WATERVIEW EAST PRELIMINARY PLAN

LOCATED IN A PORTION OF SECTION 9, T15S, R65W OF THE 6TH P.M.,
 EL PASO COUNTY, STATE OF COLORADO

PCD File # SP-17-010

Conceptual 150' * ICD Roundabout

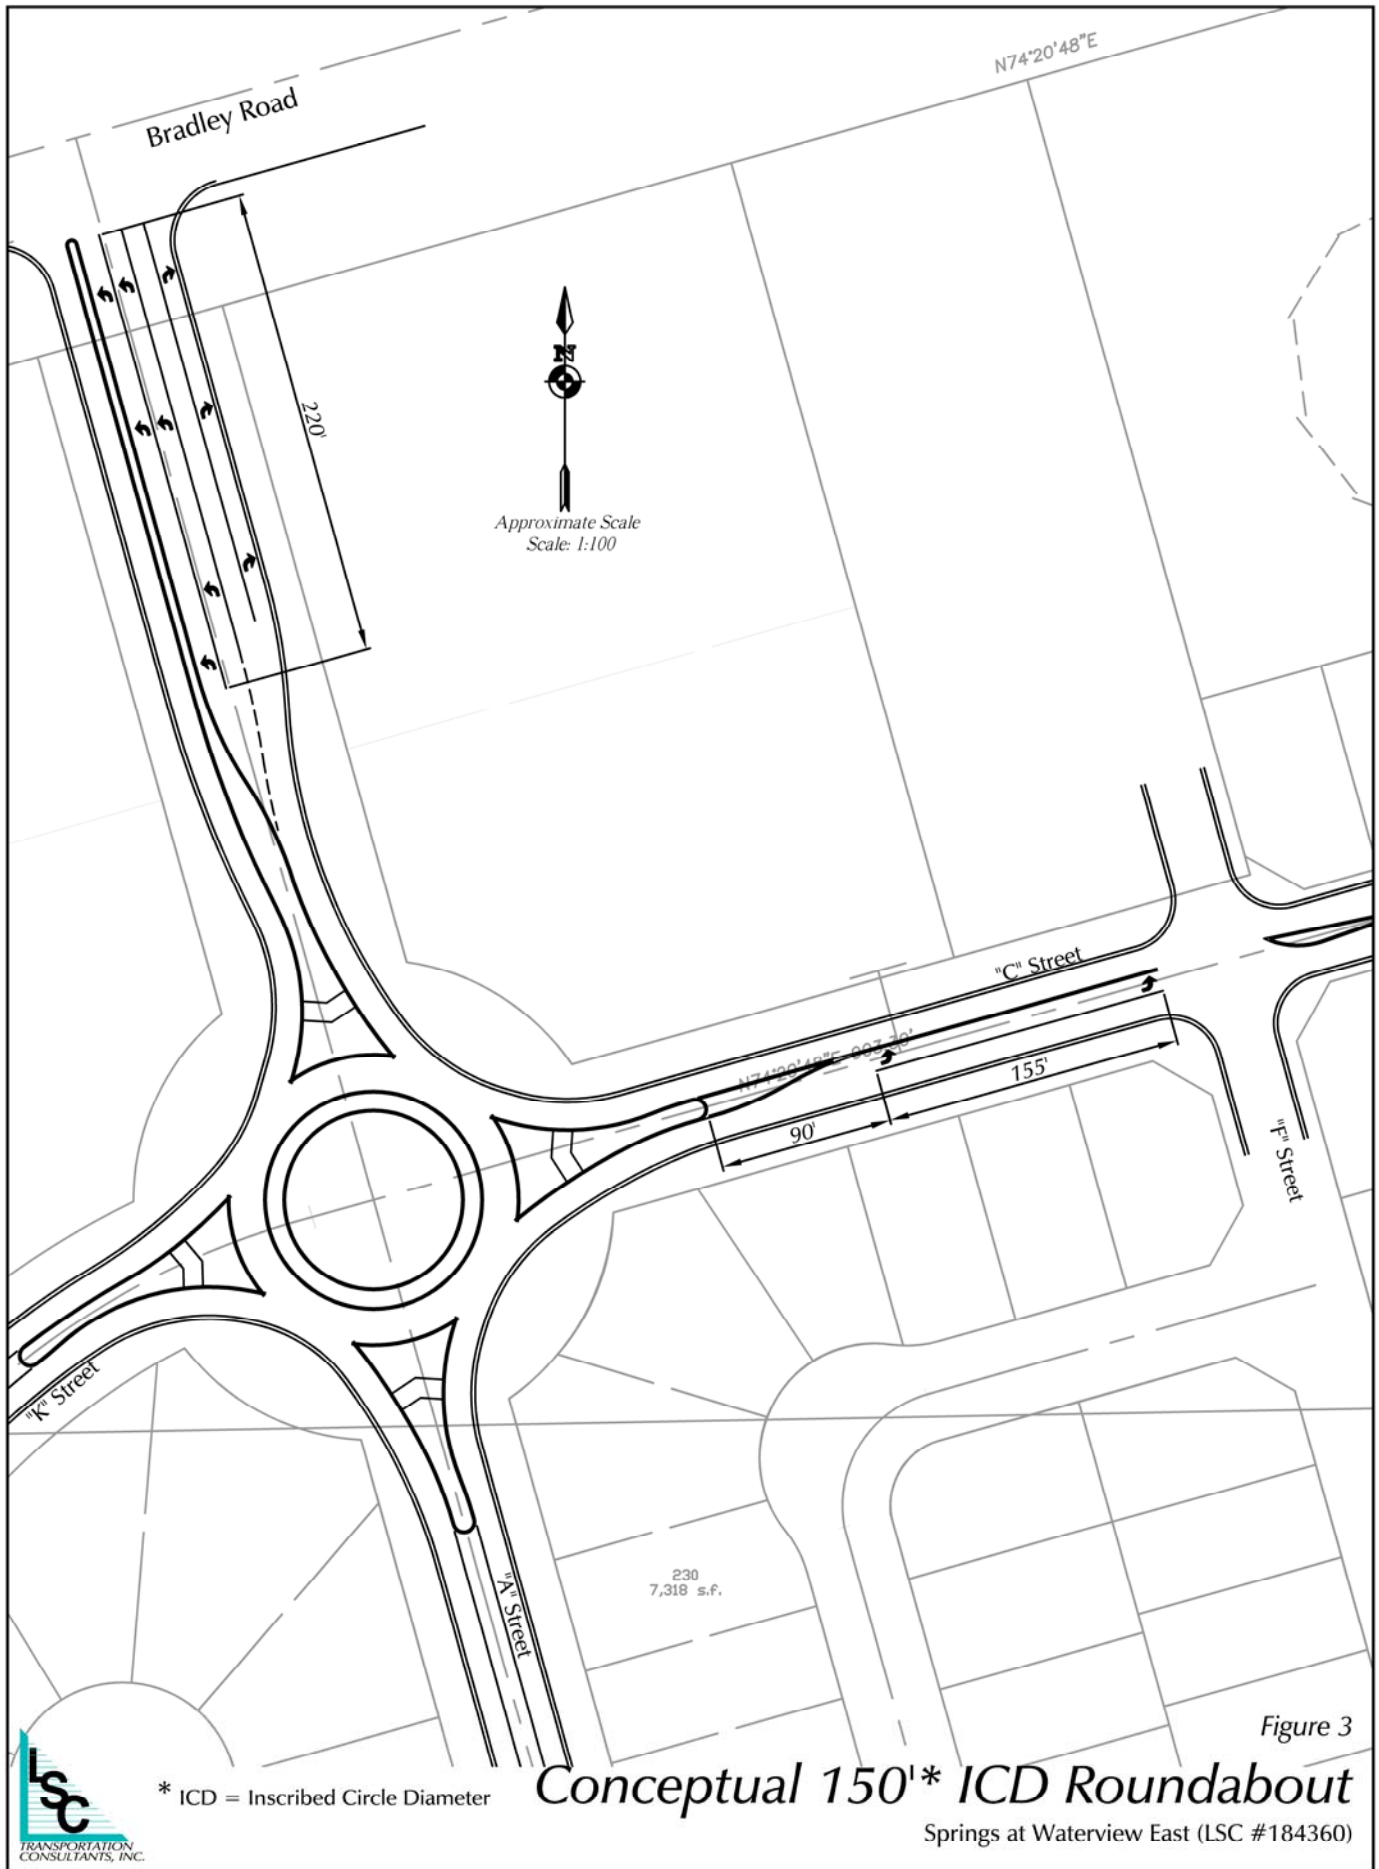
The roundabout design will need to be finalized at this stage because there is no standard in the ECM. If the roundabout, when finally designed, is larger than anticipated you will lose lots and will need to redesign and resubmit for an amendment to the preliminary plan.

If you choose not to complete the design at this stage you are doing so knowing the risk and the likelihood of there being a need for an amendment to the preliminary plan prior to the final plat being approved/heard.
